City of Albuquerque
Stormwater Construction Site
Inspection Report

Project Name and Location	Broad Stone Northpoint San Mateo and Modesto		
Site Contact Name & Agency	Lee Riley Alliance	ESC File No. NPDES ID No.	B18E001C NMR10007T
Date of Inspection	10-10-18	Start/End Time	9:45 / 10:30
COA Inspector Name	Curtis Cherne, Stormwater Quality		
Describe Present Phase of Construction	Stabilized

Site: Broadstone Northpoint

Re: Drainage Ordinance (14-5-2-1) Violations for Construction Site Waste(s) and Erosion and Sediment Control

Unprotected inlet next to dirt road with construction traffic.

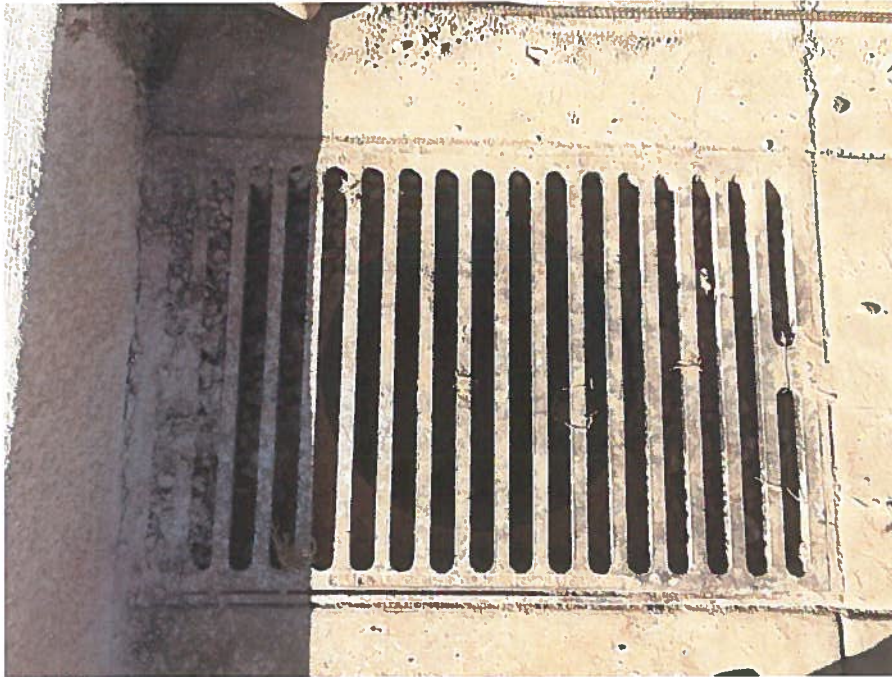
1. Concrete wash-out in the gutter/street on Modesto Ave.
2. Concrete wash-out in valley gutter on-site.
3. Numerous instances of wash-out throughout the site.
4. Unprotected inlet next to dirt road with construction traffic.

Thanks Curtis, I will reach out to the construction team and get these issues resolved quickly.
